7 May 2012

**CORMORANT ROAD / TOURLE STREET (MR108) AND INDUSTRIAL DRIVE (MR316):
EXHIBITION OF ENVIRONMENTAL ASSESSMENT FOR PORT WARATAH COAL SERVICES
TERMINAL 4 (MP 10_0215)**

Dave Young
Manager, Land Use Development
Development North
Infrastructure Development

**Hunter Regional
Development Committee**

Future site access plan showing proposed intersection improvements

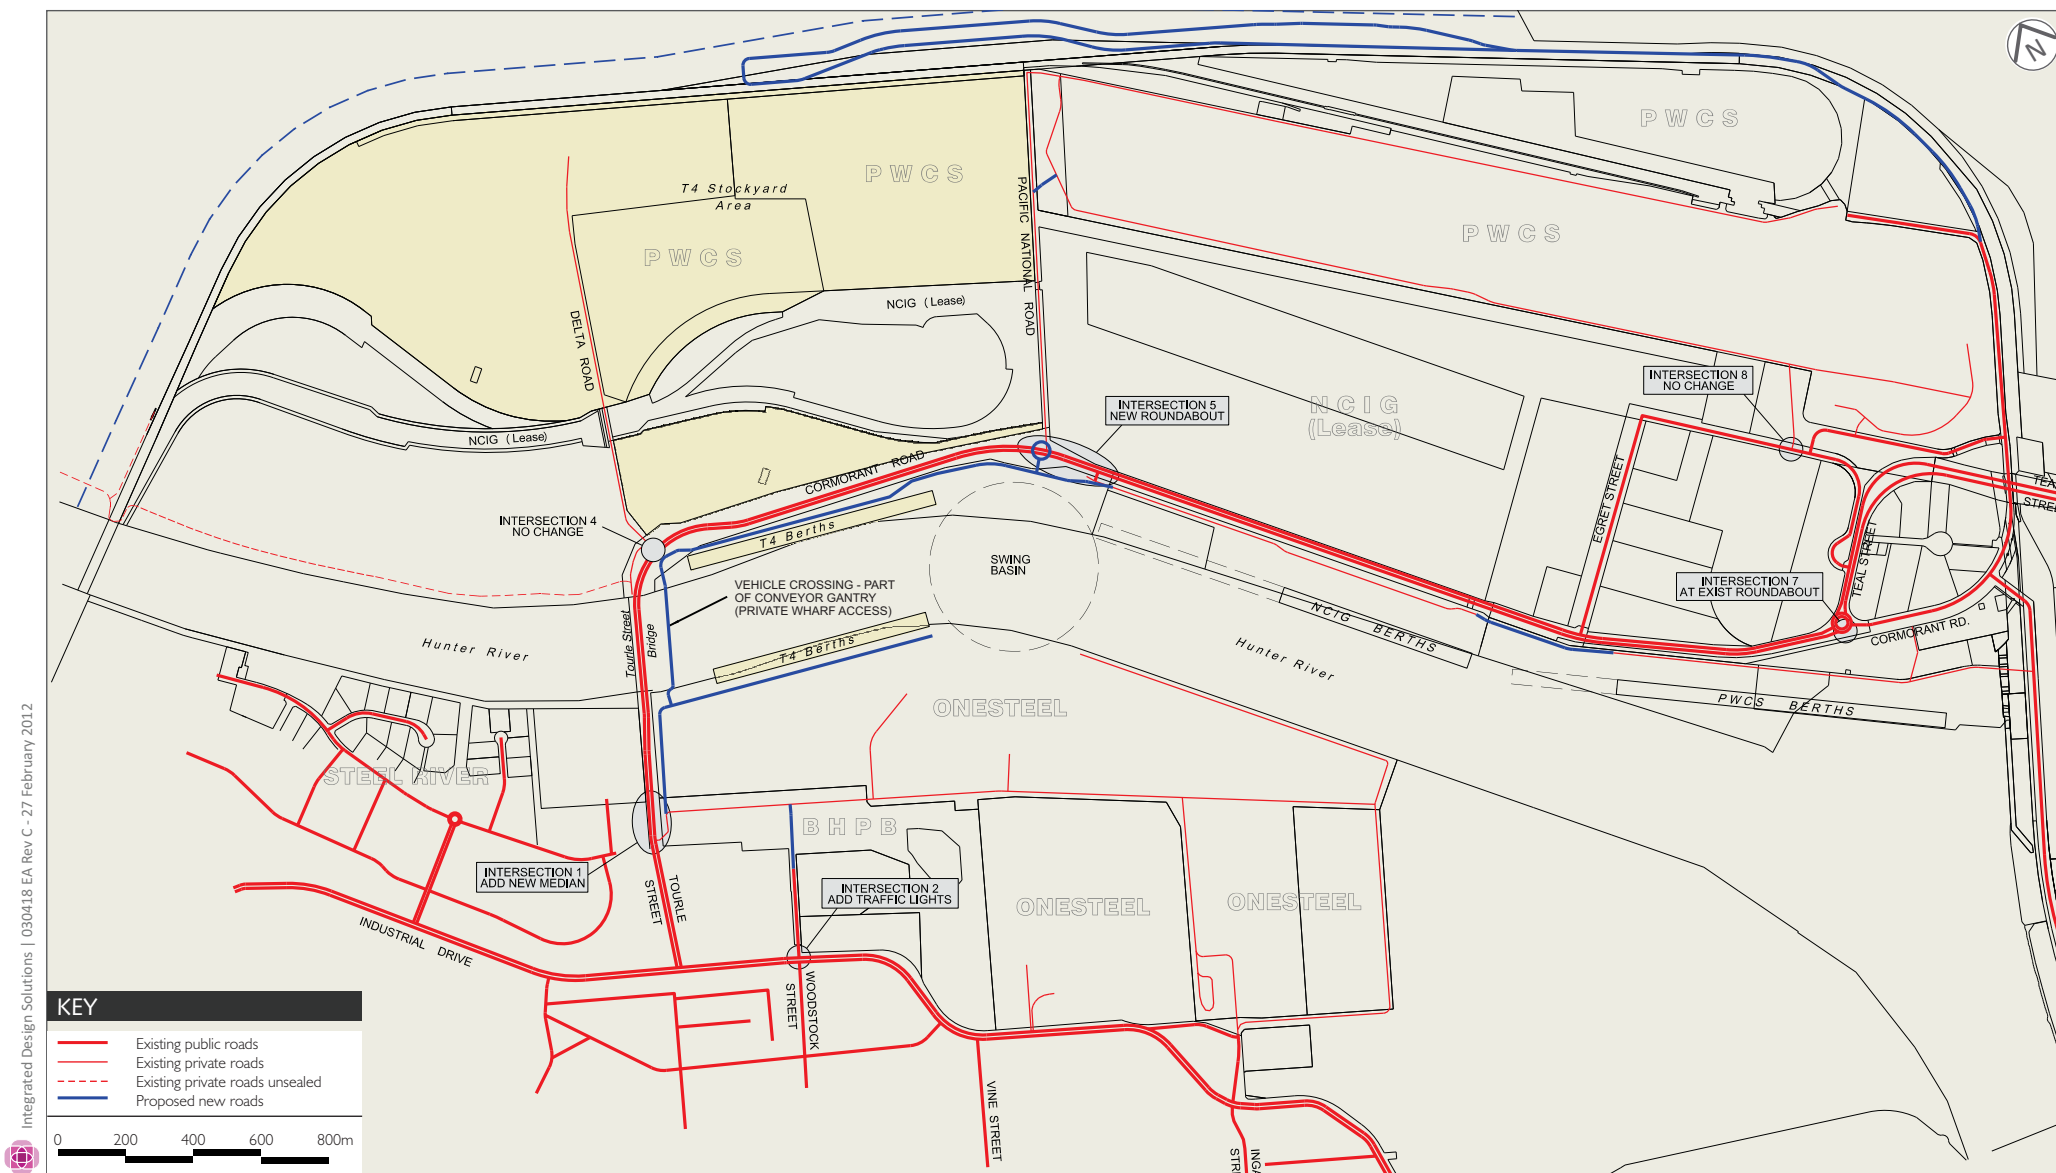
1. Cormorant Road / Pacific National Access Road / Terminal 4 Eastern Access Road

- Prior to the issuing of a construction certificate for Stage 1 works the developer shall upgrade the existing Cormorant Road / Pacific National Access Road intersection. The intersection shall be designed and constructed in accordance with the Austroads *Guide to Road Design 2009* (with RMS supplements) and the RTA *Traffic Signal Design 2008* (where TCS intersection is agreed by RMS to be the best option) to the satisfaction of RMS including, but not limited to, the following works:
 - Upgrading the intersection to a four leg traffic signal controlled intersection or alternatively a four leg circulating roundabout.
 - The required lane configuration, types and lengths shall be determined by RMS subject to a review of the requested revised traffic analysis to be prepared to the satisfaction of RMS in accordance with the RTA's *Guide to Traffic Generating Developments*.

- Signalised pedestrian crossings shall be provided on all legs.
- Street lighting shall be provided to Australian Standards.
- The intersection shall be designed and constructed to accommodate on-road cyclists unless specified otherwise by RMS. If cyclists cannot be accommodated on road due to site constraints, and subject to the agreement of RMS, adequate provision shall be made off-road.
- This work shall be designed and constructed to suit the future duplication of Cormorant Road.

- Prior to the issuing of a construction certificate for Stage 2 works the developer shall upgrade the Industrial Drive / Woodstock Street intersection. The intersection shall be designed and constructed in accordance with the Austroads *Guide to Road Design 2009* (with RMS supplements) and the RTA *Traffic Signal Design 2008* to the satisfaction of RMS including, but not limited to, the following works:
 - Upgrade intersection to a three or four leg traffic signal controlled intersection.

Comment: RMS is currently awaiting advice from Council regarding whether Woodstock Street (South) will continue to have unrestricted access on to Industrial Drive or if it will have restricted in / out movements or closed altogether. This is in response to concerns about large numbers of heavy vehicles travelling through the quiet residential area to the south of Industrial Drive as a result of the proposed development.

- The required lane configuration, types and lengths shall be determined by RMS subject to a review of the requested revised traffic analysis to be prepared to the satisfaction of RMS in accordance with the RTA's *Guide to Traffic Generating Developments*.
- Signalised pedestrian crossings shall be provided on all legs.
- Street lighting shall be provided to Australian Standards.
- The intersection shall be designed and constructed to accommodate on-road cyclists unless specified otherwise by RMS. If cyclists cannot be accommodated on road due to site constraints, and subject to agreement by RMS, adequate provision shall be made off-road.

Note: Further traffic analysis is required for the traffic control signals option at the Cormorant Road / Pacific National Access Rd / T4 Access Road intersection.
